# City of Charlotte – Planning Dept. Scanning Rezoning Files

PETITION NO. 86-30 HEARING DATE 03/17/86

CONDITIONAL ZONING REVIEW CHECKLIST

Petition Number: 86-30

A REZONING MAP FOR
EXCELSIOR MASONIC TEMPLE

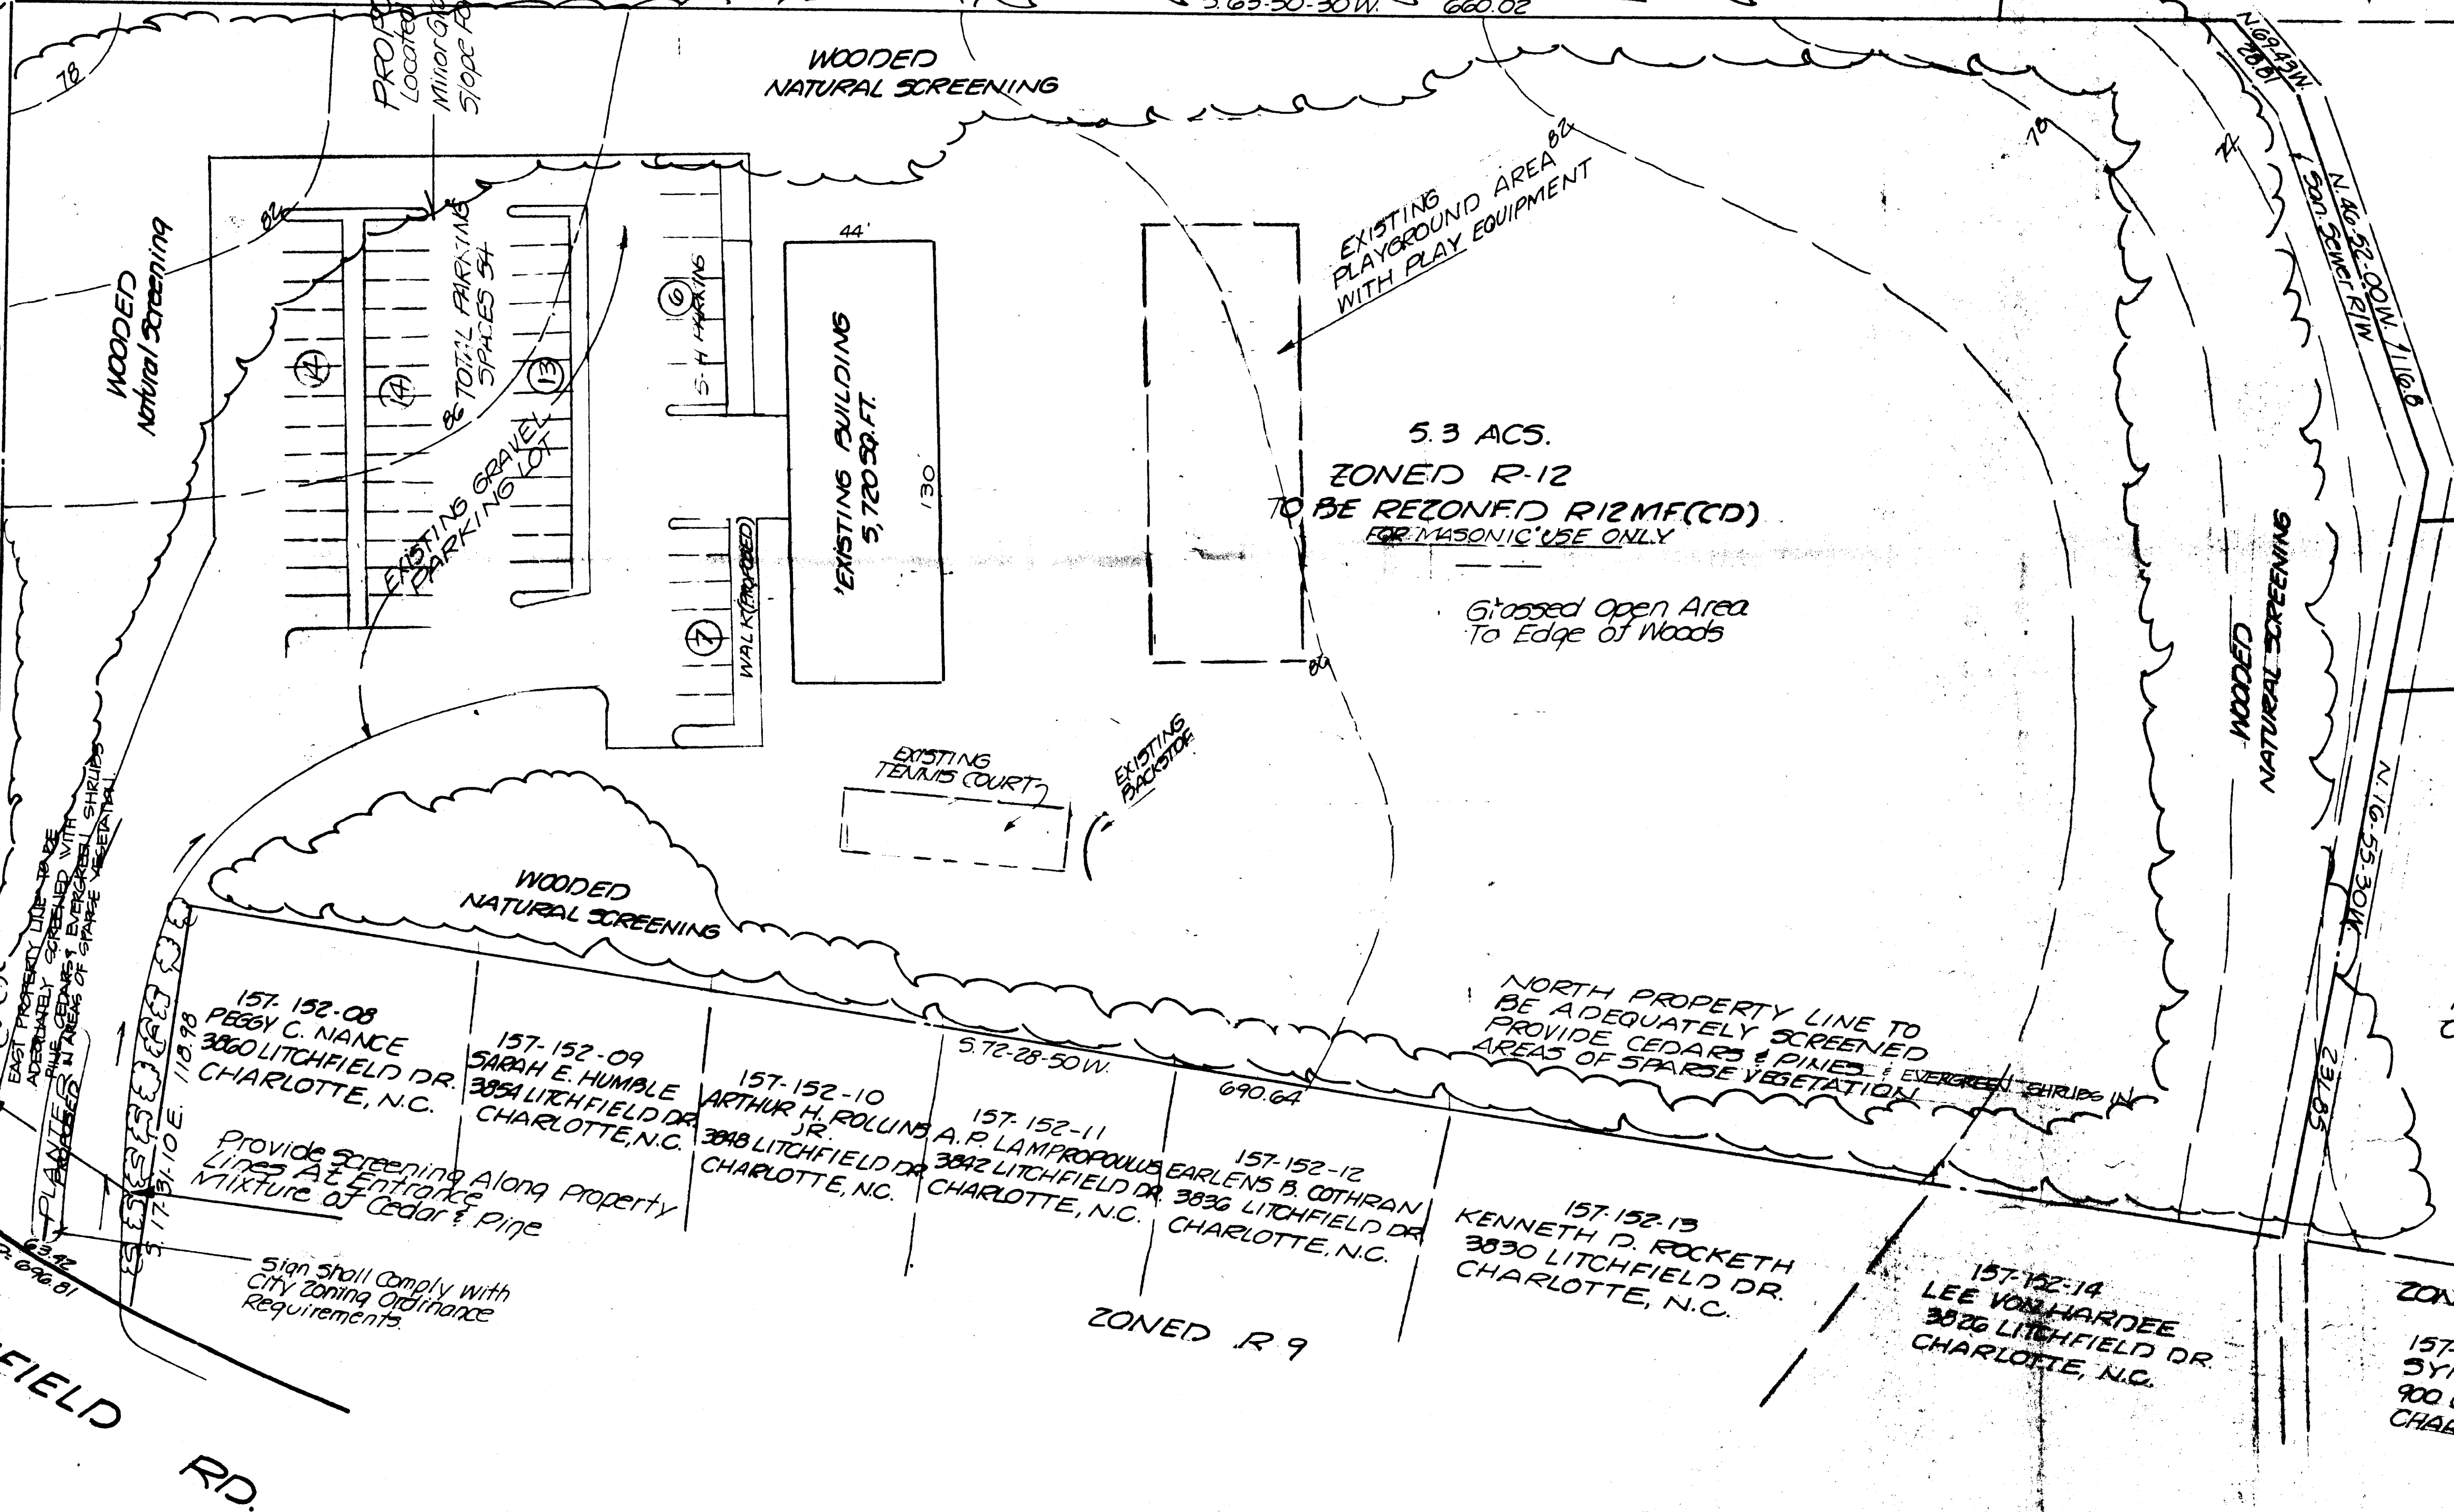
Conditions as per Approved Site Plan: 1) Built; screening inadequate; 2) entrance drive and northerly property line are not adequately screened; 3) need evergreen shrub plantings see note on drawing; 4) plan indicated natural wooded which is not as dense as it implies.

Staff Recommendations: Refer to ZA
